5 December 2023

Re: Hunter Valley Operations Continuation Project -Response to Resource Regulator Advice

This letter addresses matters raised in the NSW Resources Regulators (RR) advice on the Hunter Valley Operations (HVO) Continuation Project (the Project) - Environmental Impact Statement (EIS, EMM 2022).

Figure 3.3 Proposed conceptual final landform design; HVO North

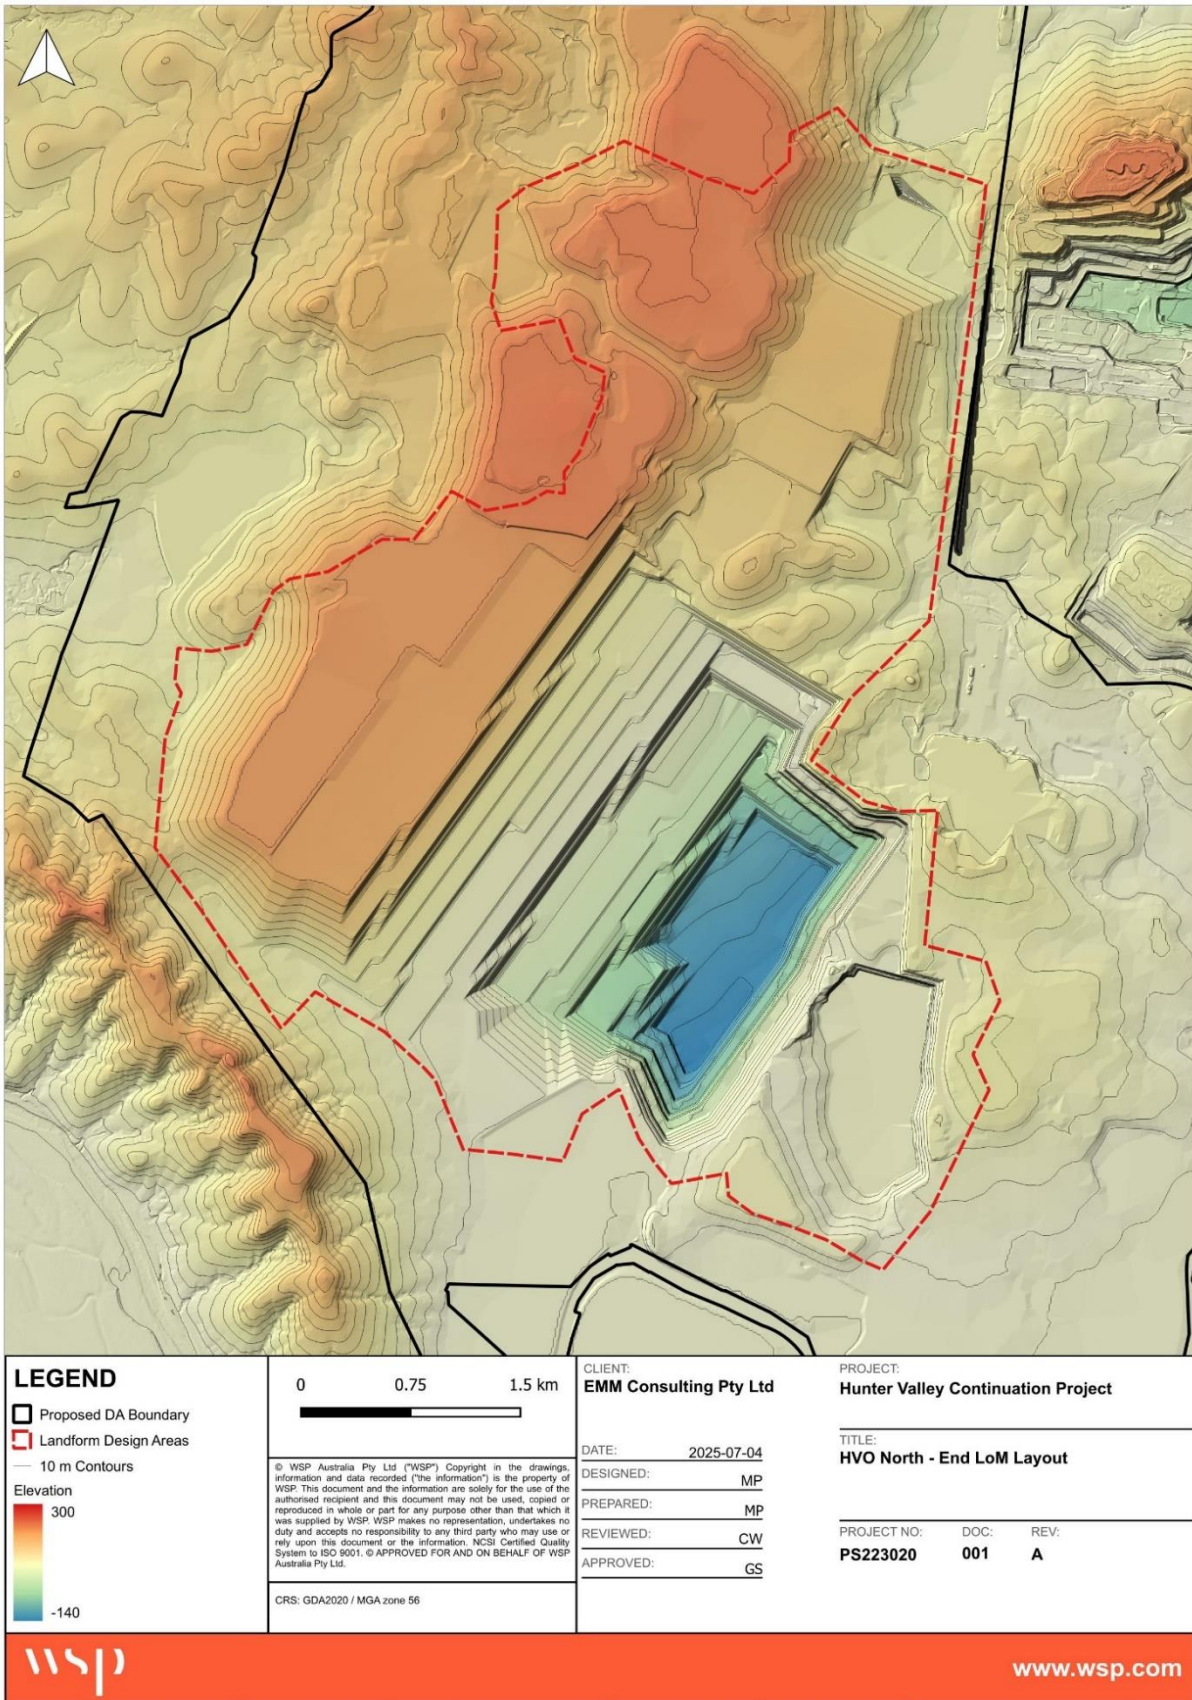
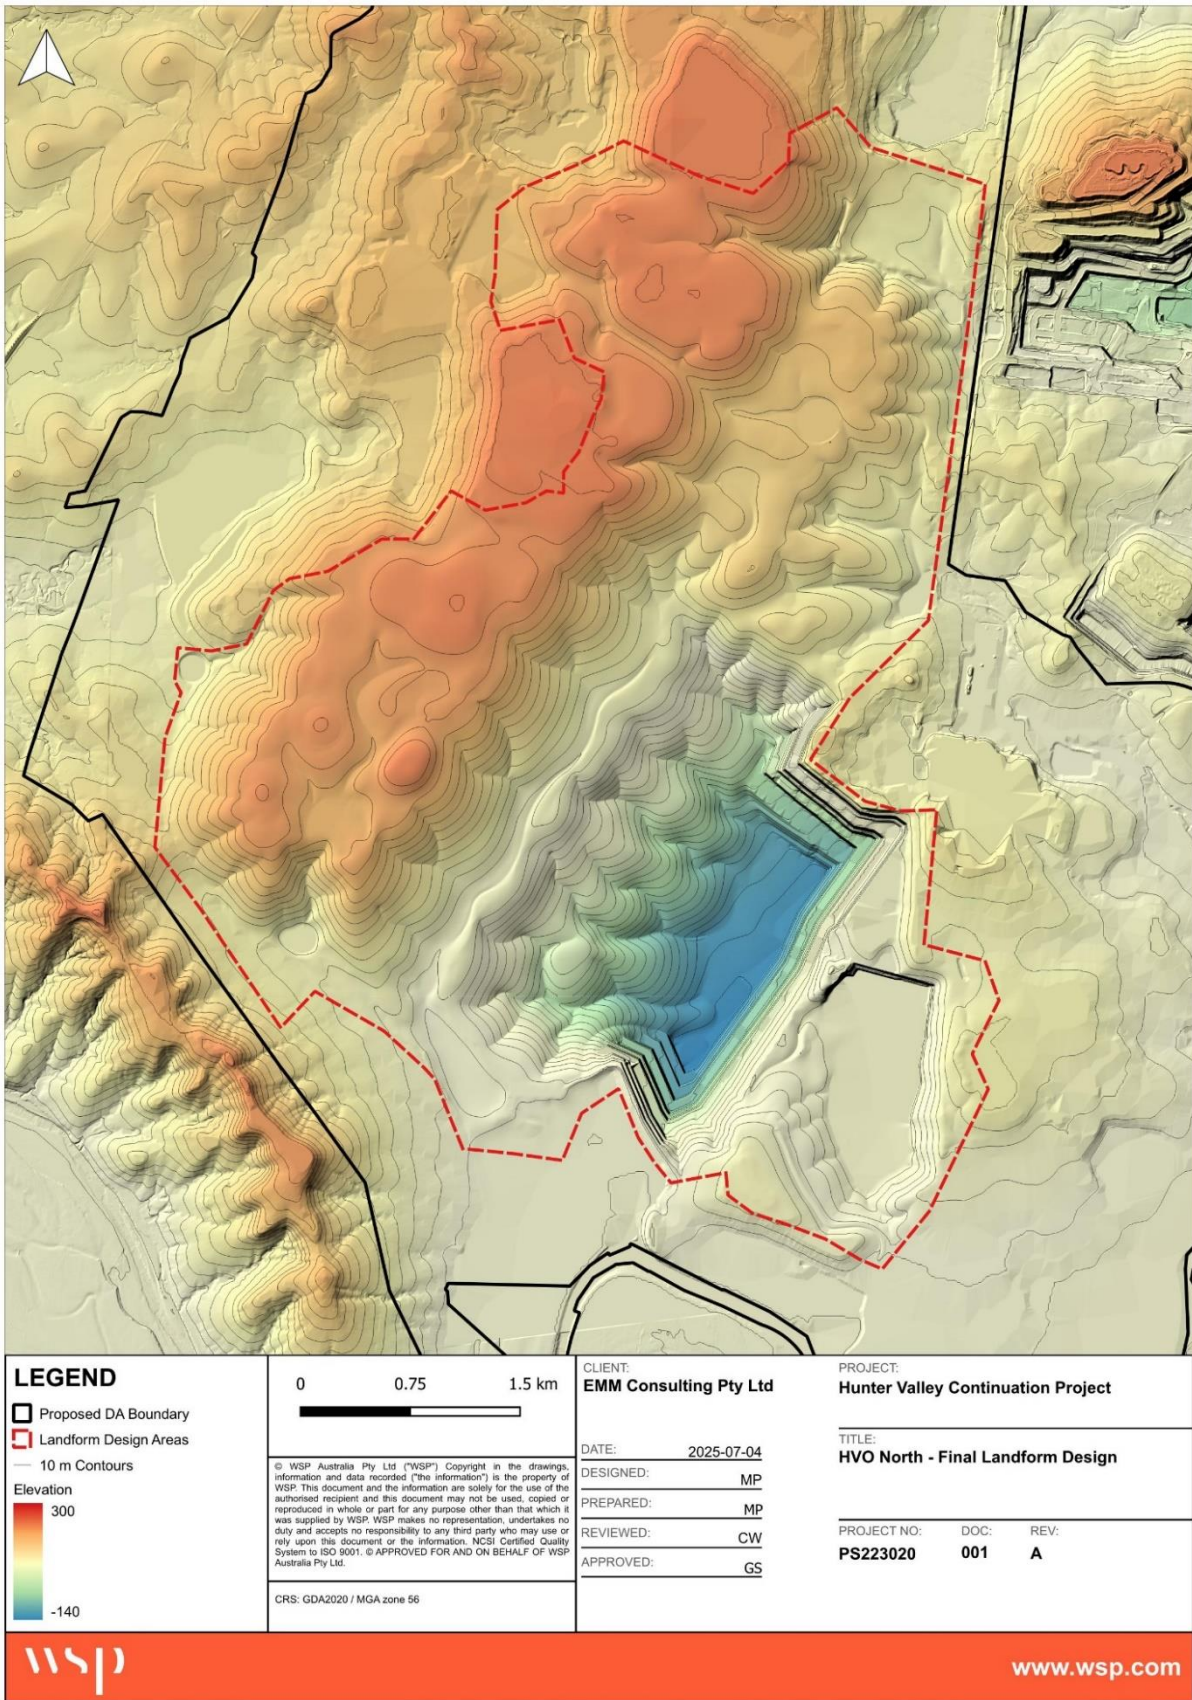
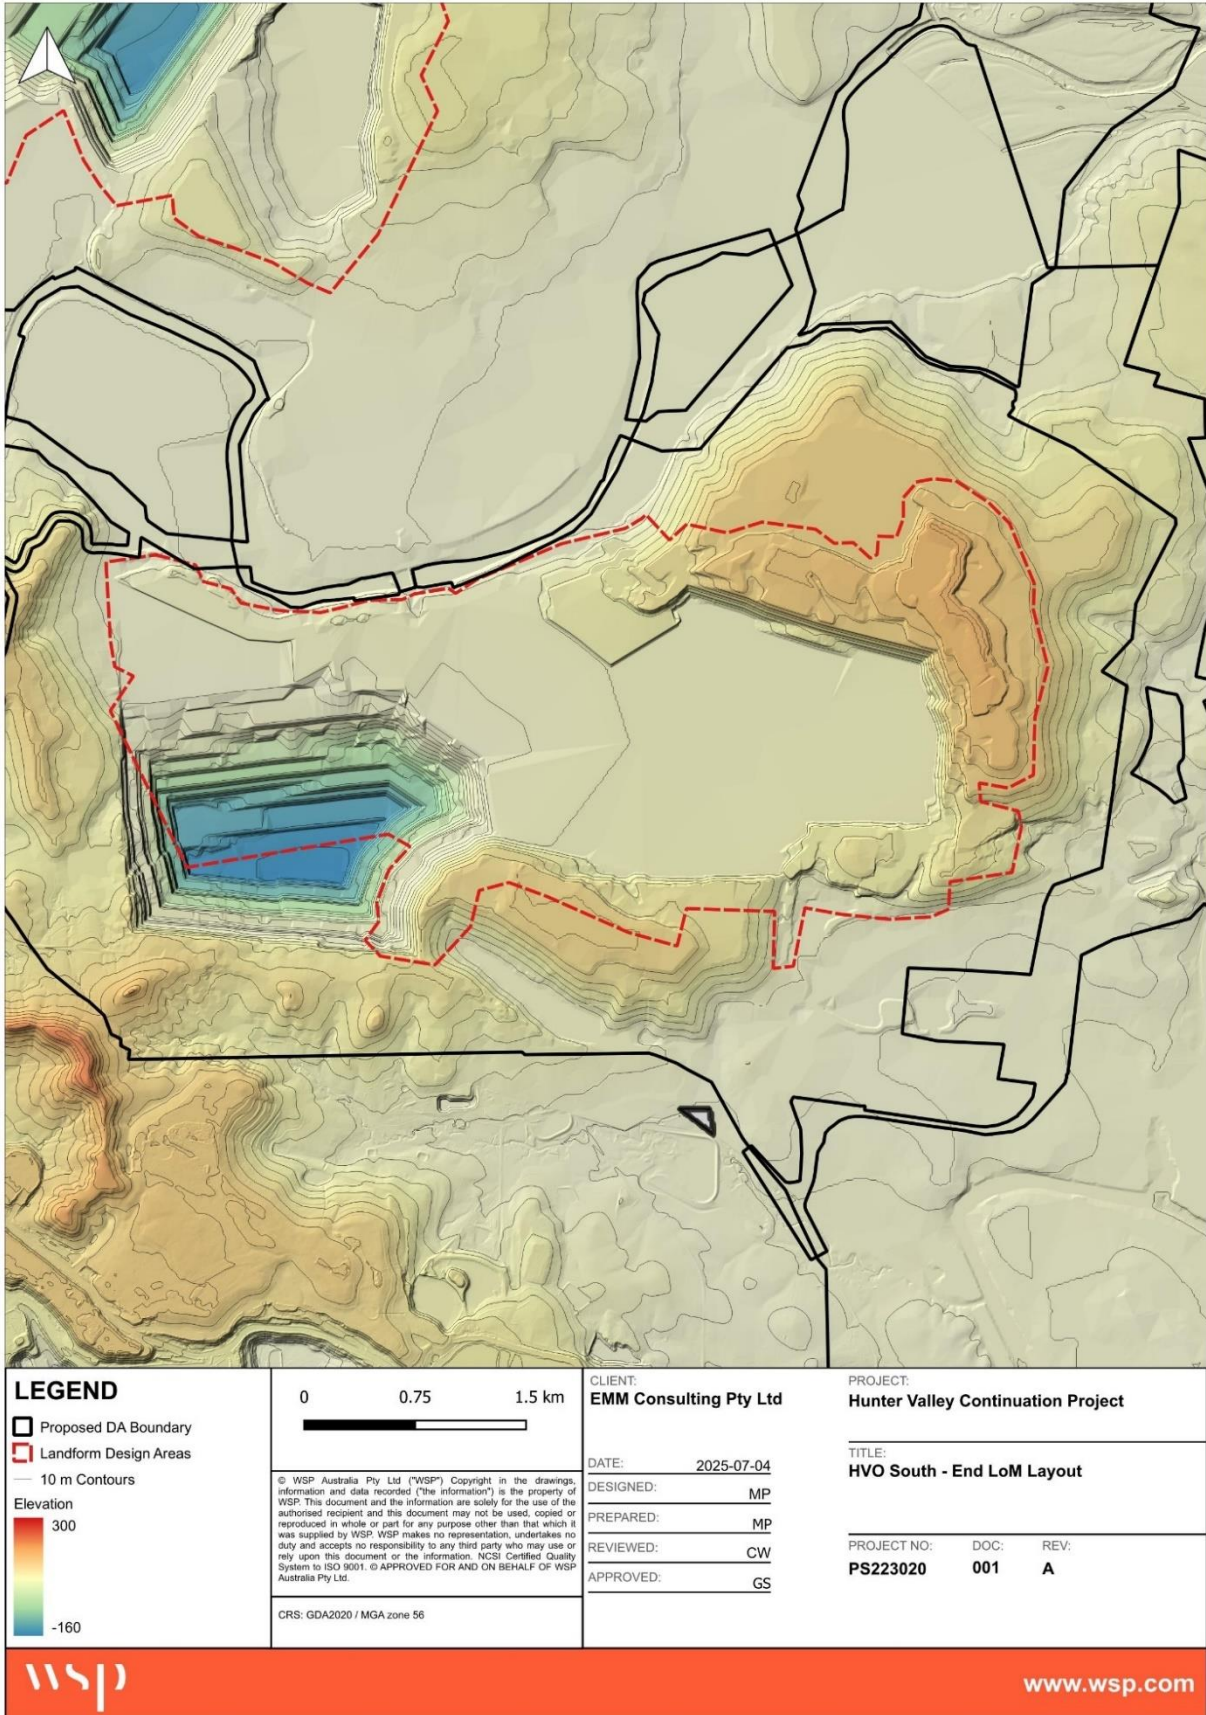
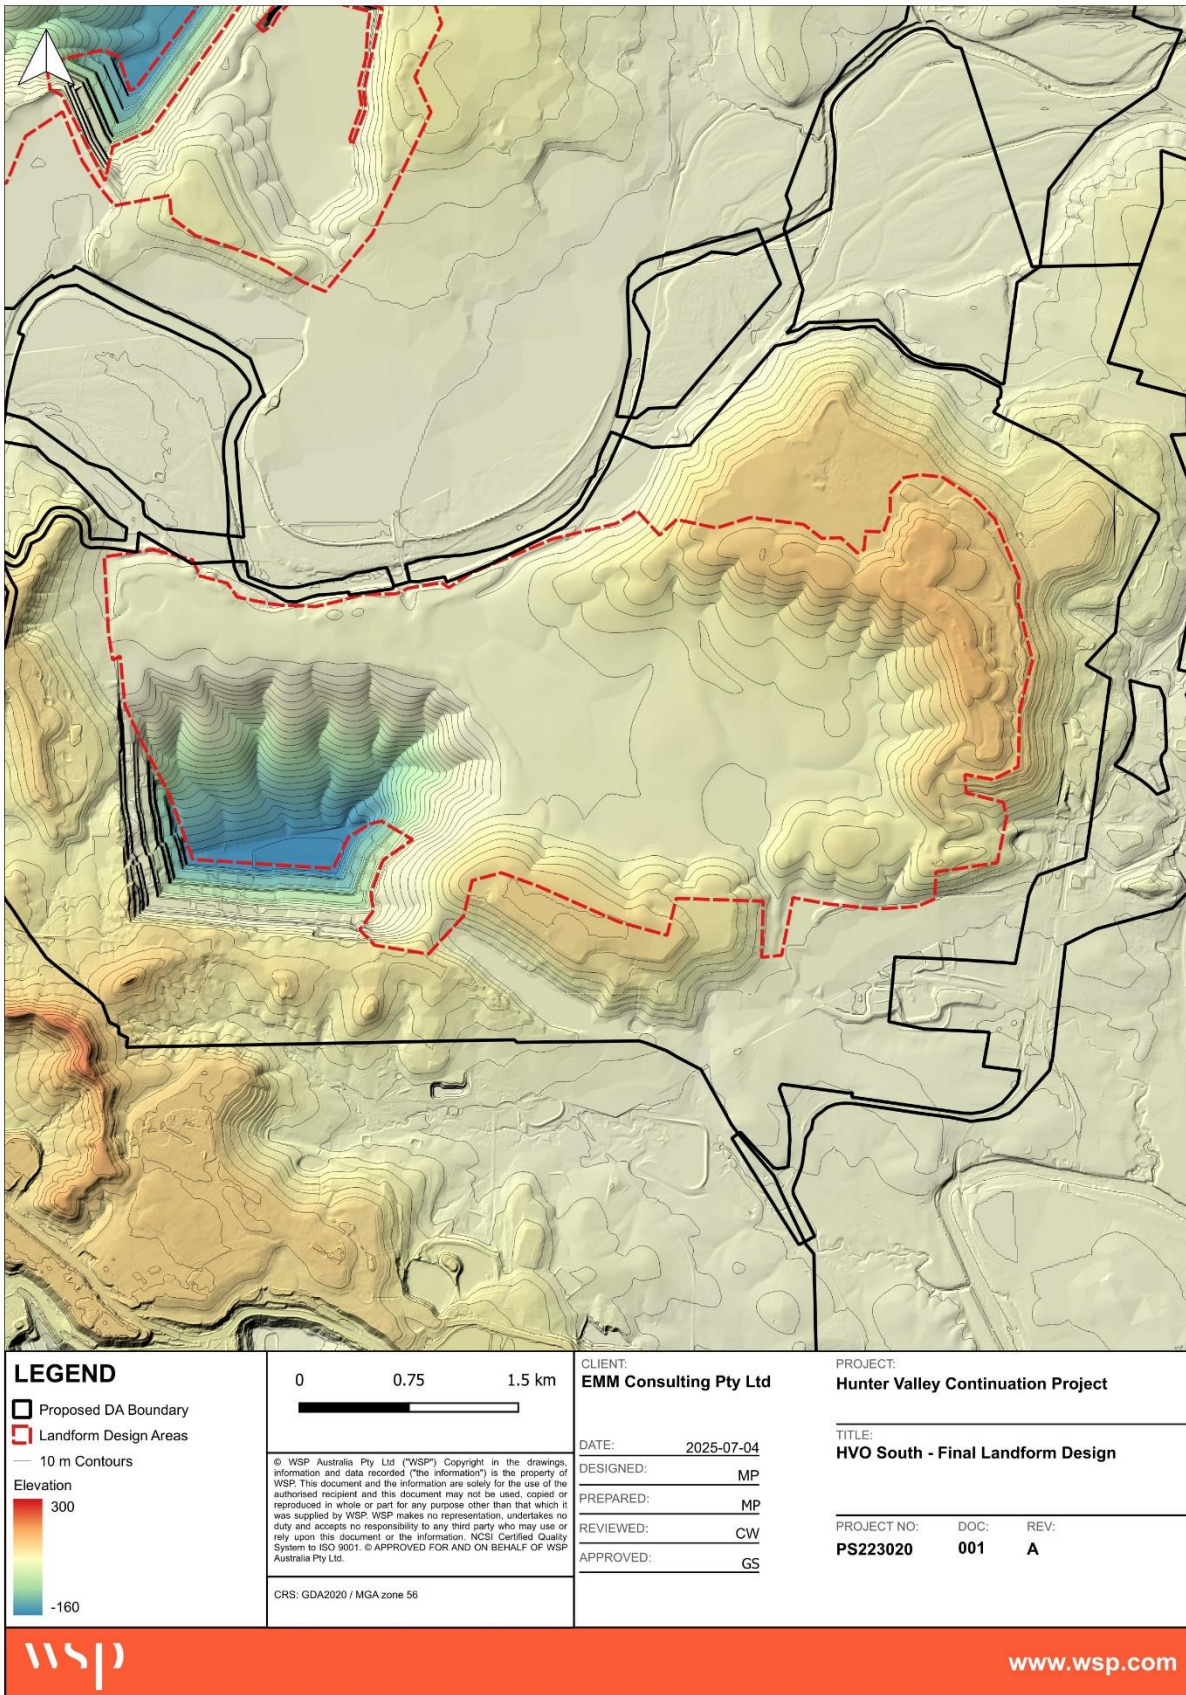
Clarification that the capping design for all TSFs will support the growth of trees associated with native vegetation final land use either overlaying or adjacent to the TSFs. If capping design cannot accommodate tree growth, further information is required on how this is managed as a post-closure maintenance activity.

All active and proposed TSFs within the HVO final landform are to meet the objectives of Domain A – Native ecosystem or Domain B – Agriculture grazing as described in Section 5.2 of the Strategy. This objective is reflected on conceptual final landform plans for both HVO North and HVO South as presented in the Figure B.15 and Figure B.16, respectively within the HVO Continuation Project Amendment Report (Amendment Report, EMM 2023).

Individual facility closure and capping management plans are proposed to be developed prior to closure of the facilities as noted within Section 7.1.2 of the Strategy. These individual facility plans will outline the appropriate capping requirements to support the final land use objectives. Should post closure maintenance be required to support the final land use, such as management of trees, this will be conducted as outlined under the post-closure maintenance activities outlined in Section 8.5 of the Strategy.
